From: Anita Gardner
Sent: 29 July 2022 11:46
To: Laurence Moore <[REDACTED]>
Subject: RE: Pound Place, Angmering - Applications A/43/22

A/43/22 - Variation of condition following grant of A/3/21/PL relating to Condition No 1 - approved plans. This should have been decided by 24 June 2022

A/47/22 - Continuance of use without compliance with condition 1 imposed under A/3/21/PL relating to prior to first occupation the hatched area indicated on Site Layout Green Arrangement 1388/001 K shall be laid to be an open grassed area and shall remain, at all times, available for public use. This should have been decided by 9 June 2022.

Drawing title
Landscape General Arrangement Plan

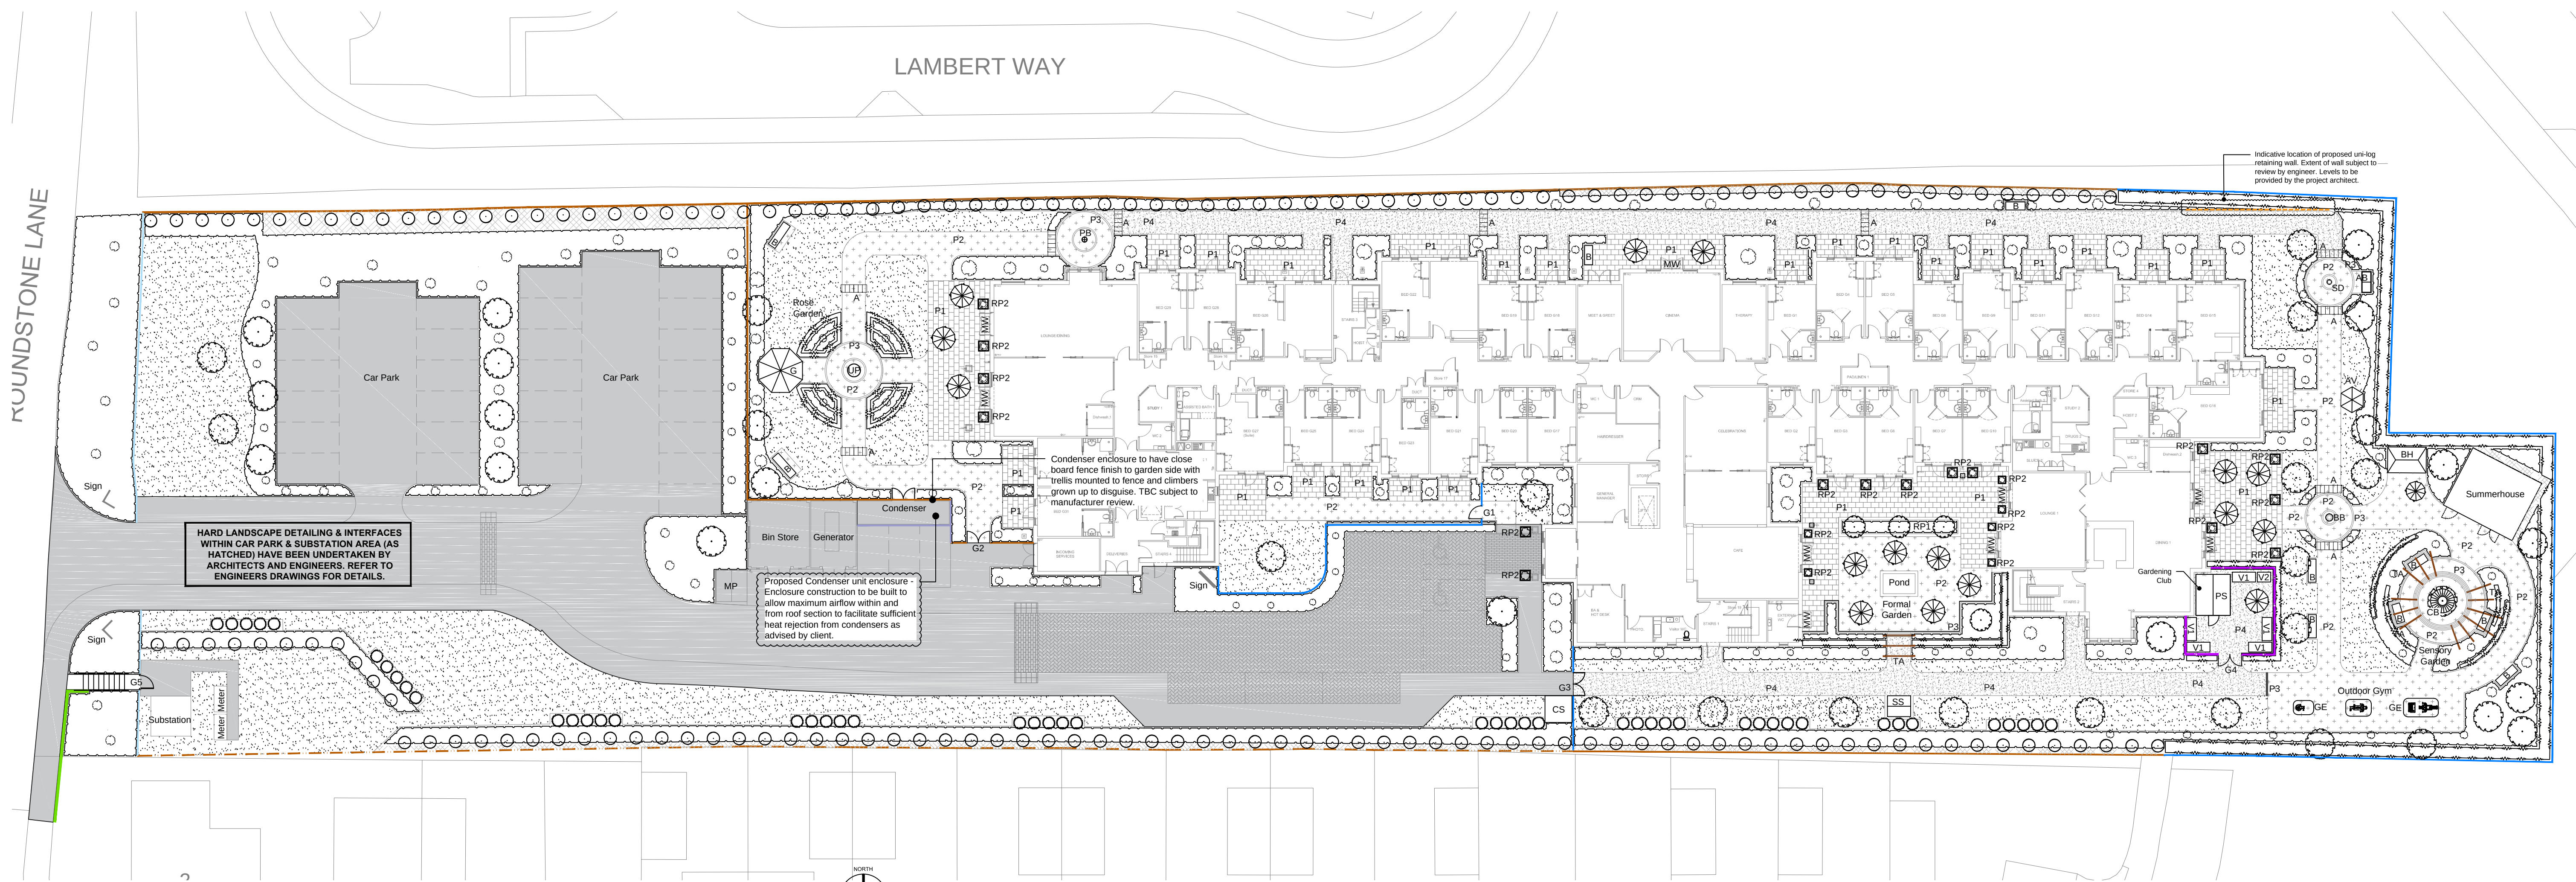
There is however one matter which we believe already has the benefit of permission. When Planning permission was granted under A/3/21PL, Drawing J180649-GL-L-DR-001 Rev B – Landscape General Arrangement Plan shows the Proposed 1.8m high hoop top metal rail fencing in the same position as shown in the current applications.

Extract of the eastern part of the site reproduced below from Drawing J180649-GL-L-DR-001 Rev B – Landscape General Arrangement Plan. The blue line denotes 'Proposed 1.8m high hoop top metal rail fencing'.

This is the same as what is being proposed in the current applications A/43/22 Extract from Drawing No. J180649-GC-L-DR-3-001 Rev H reproduced below.

I have now had an opportunity to discuss the application with my Team Leader, Juan Baeza and he agrees that the items detailed in my e-mails below namely bbq hut, summerhouse, hoop top fencing and removal of TPOd trees should be deleted from the application if it is to be recommended for approval by officers.

I have fully reviewed the application and checked the proposed changes against the planning history. I note that the garden section of the site facing onto public open space was permitted to be enclosed with 1.8m high hoop top fencing previously (A/50/20/PL), but it was always envisioned that this part of the site should visually integrate with the open space beyond it. I note that a summerhouse and bbq hut are proposed to be located in this area and both would be visually prominent, particularly the summerhouse (although no specific details are included) which extends through previously approved boundary planting.

Further to my earlier e-mail I had initially assumed that the proposal was largely seeking approval of matters previously agreed for the earlier approved care home. On further inspection of the information submitted I note that the proposed revision to the Landscaping Plan includes removal of

TPO'd trees on the Roundstone Lane site frontage and there is no arboricultural justification given for this in the submission and no up to date report assessing the health and life expectancy of these trees.

I would therefore suggest that the landscaping plan is amended to retain these trees so that the other matters can proceed to a decision. If the tree removal element is pursued as part of this proposal it is likely to be refused given the lack of justification provided. Replacement of the preserved trees would obviously be a matter which could then be pursued separately as part of an application in its own right to further amend the approved landscaping scheme.

I have been looking at application A/47/22 in more detail and having checked the planning history in more detail I agree that it has been accepted that the hoop top fencing has been approved in this location and this element of the proposal would not be recommended for refusal.
